1 l) New Services

1 m) Original Fabric Removal

Walsh Bay Arts Precinct

Figure 69: Level 1 Performance Spaces Pier 2/3

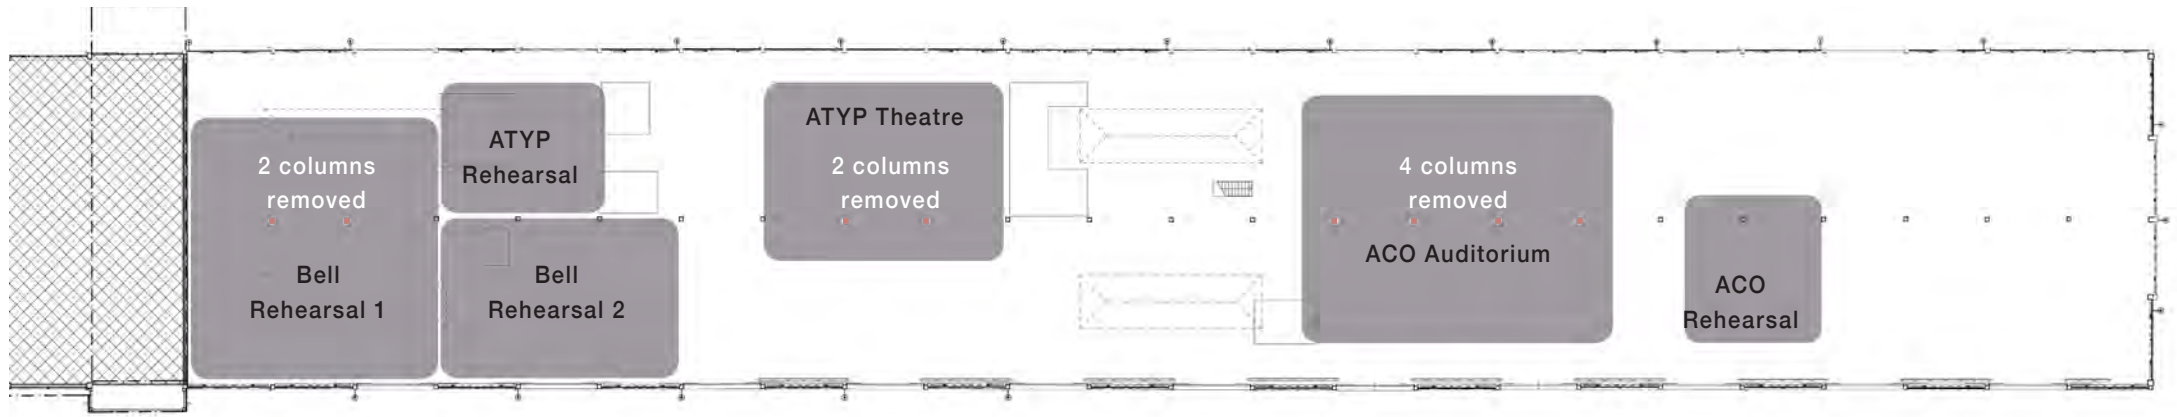
Heritage Council Comment 1 m)
There is a significant amount of original fabric that is proposed to be removed including original timber columns, timber trusses, brace beams and steel strong backs to obtain completely open areas in the theatres and rehearsal rooms. In developing the further design details, the impacts to these components must be minimised. Any significant fabric that is removed and not proposed to be reused must be recorded, tagged and securely stored on-site for future use. A removal and storage methodology must be provided prior to the commence of works.

Response
The Applicant has no objection to this suggested condition.

Significant fabric that is removed and not proposed to be reused will be recorded, tagged and securely stored onsite for future use.
